Application Ref:	2026/0298			 Ribble Valley Borough Council www.ribblevalley.gov.uk
Date Inspected:	21/05/2026	Site Notice:	21/05/2026	
Officer:	EP			
DELEGATED ITEM FILE REPORT:				
				APPROVAL

Development Description:	Proposed demolition of existing side extension and replacement with new single-storey side extension. Existing garage to be altered internally and externally to create first floor annex accommodation
Site Address/Location:	New Laithe Lower Chapel Lane Grindleton Clitheroe BB7 4RN

PROPOSED HOUSE ELEVATIONS

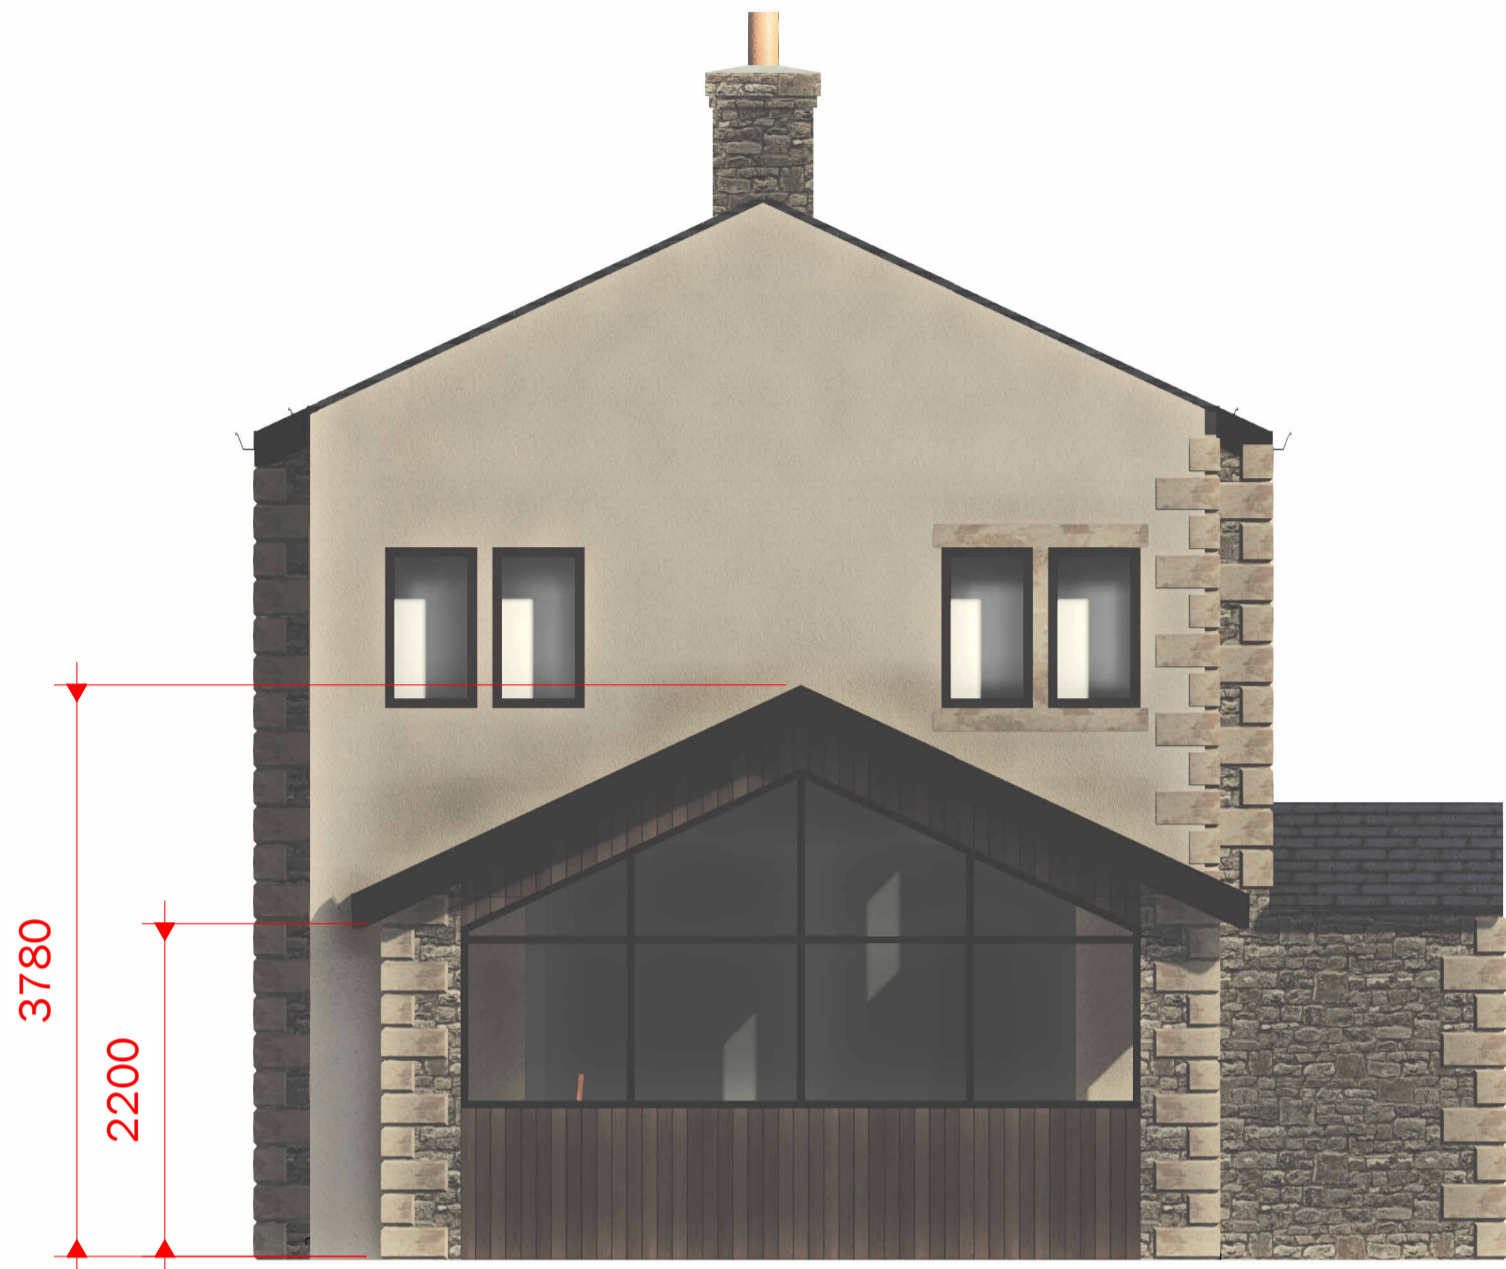
The proposed single-storey side extension in respect of scale is modest and comparable to that of the existing conservatory being just 520mm larger in width. The extension will therefore remain entirely subservient to the host dwelling and is considered acceptable from a scale perspective.

The design of the extension is simple to reflect the linear vernacular of the main dwelling. The materials reflect those found on the existing dwelling and will integrate sufficiently. It is recognised that there is a large section of glazing proposed on the side elevation of the extension, which may appear more contemporary in nature. However, particularly taking into consideration the fact the extension will replace the existing entirely glazed conservatory, and paired with the existence of several large sections of glazing on the existing main dwelling, it is not considered this would look out of character.

SHEET:  
PROPOSED ANNEX PLANS AND  
ELEVATIONS

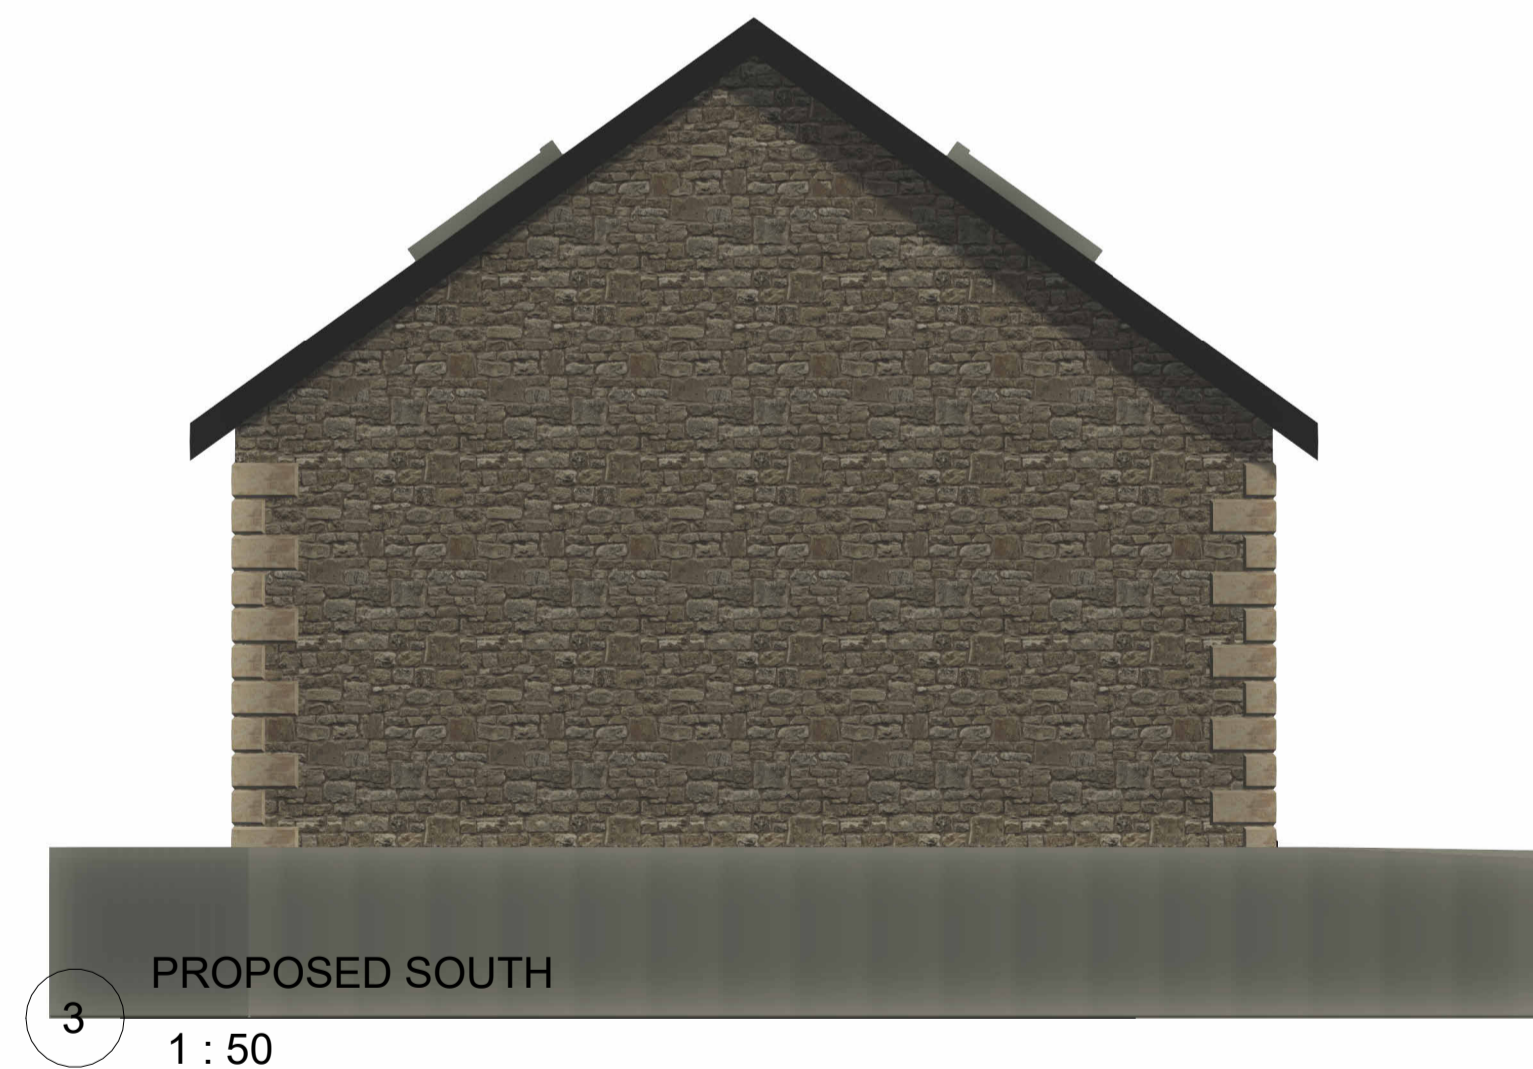
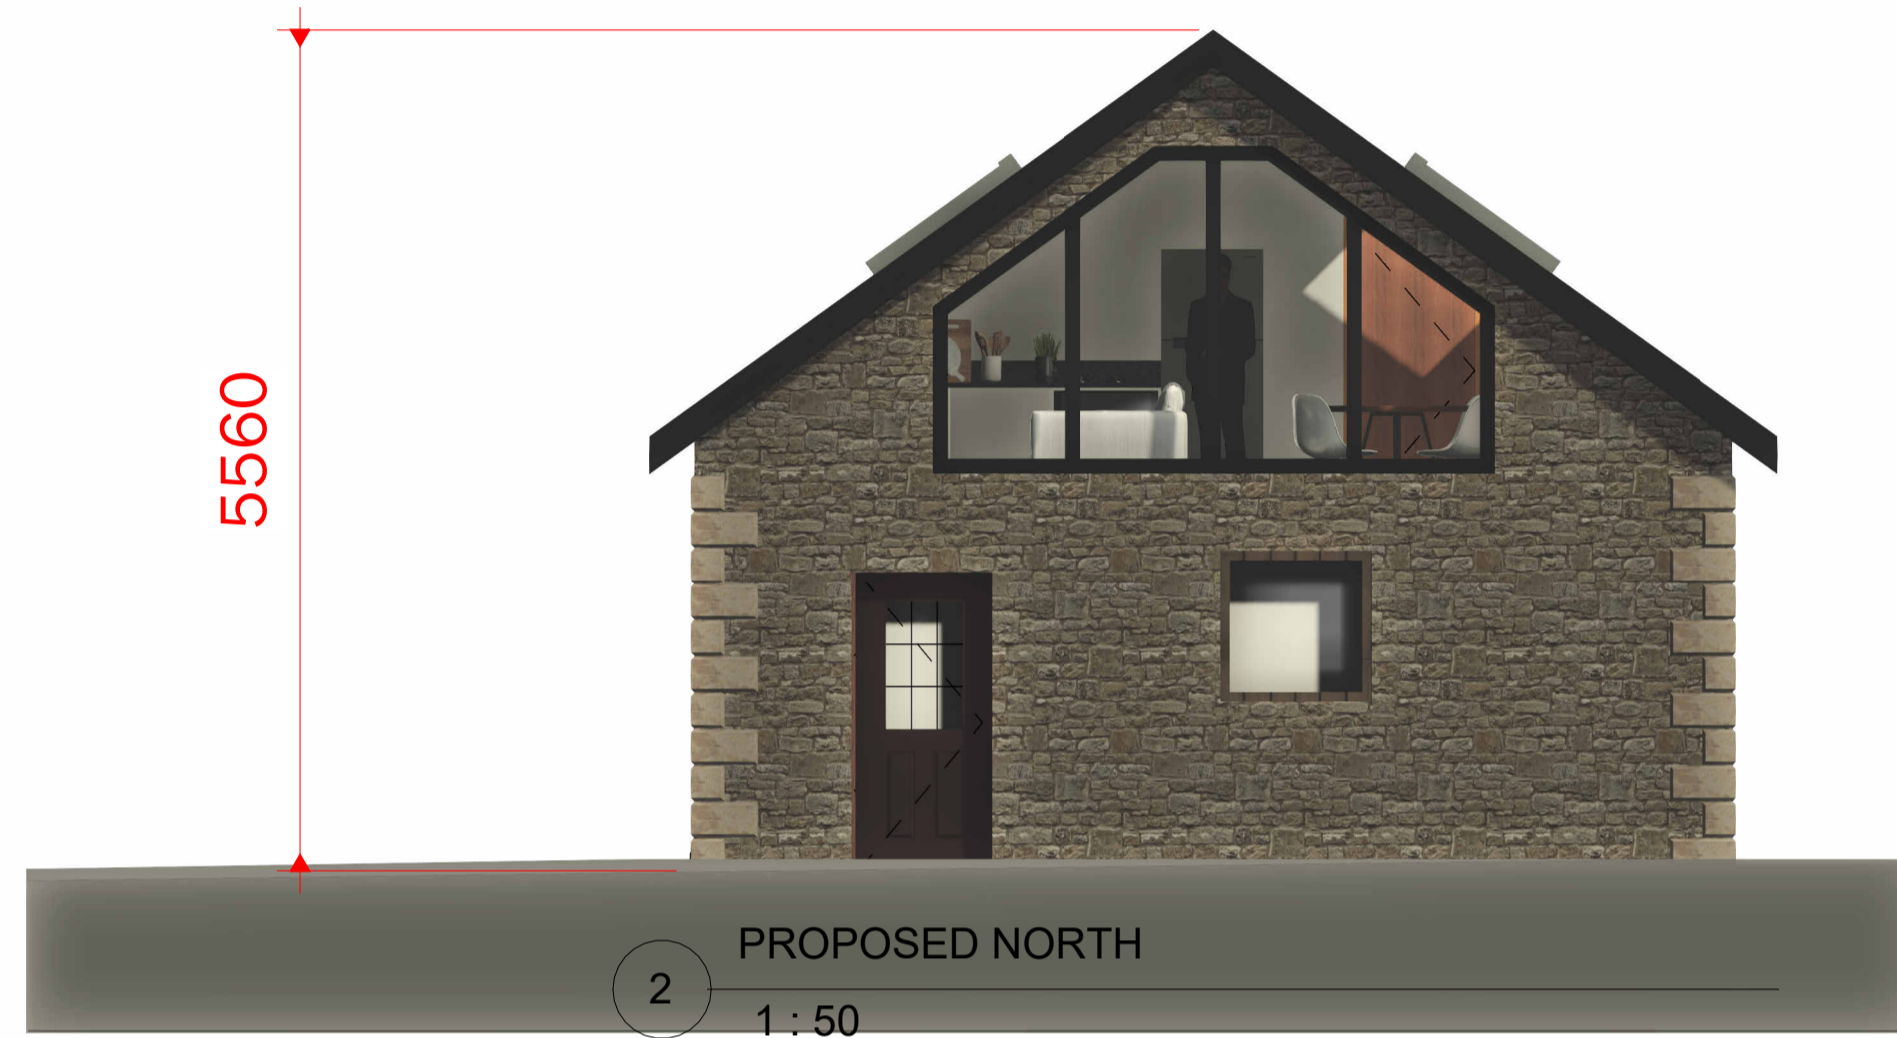
The accommodate annex accommodation within the first floor, the existing garage will benefit from a marginal roof lift. This will take the eaves and ridge from 2.3m and 4.75m respectively to 2.5m and 5.56m. It is not considered that this small increase would result in the structure taking a dominant position within the residential curtilage or wider street scene.

In respect to other design alteration, a new access door will be positioned to the rear of the building to provide access to the annex accommodation. The southeastern side elevation will feature large sections of glazing. Given these elevations are not visible from the highway or wider public realm, this is not considered to be of harm the character of the site or wider area. Although these elements are more domestic in appearance, they are well screened.
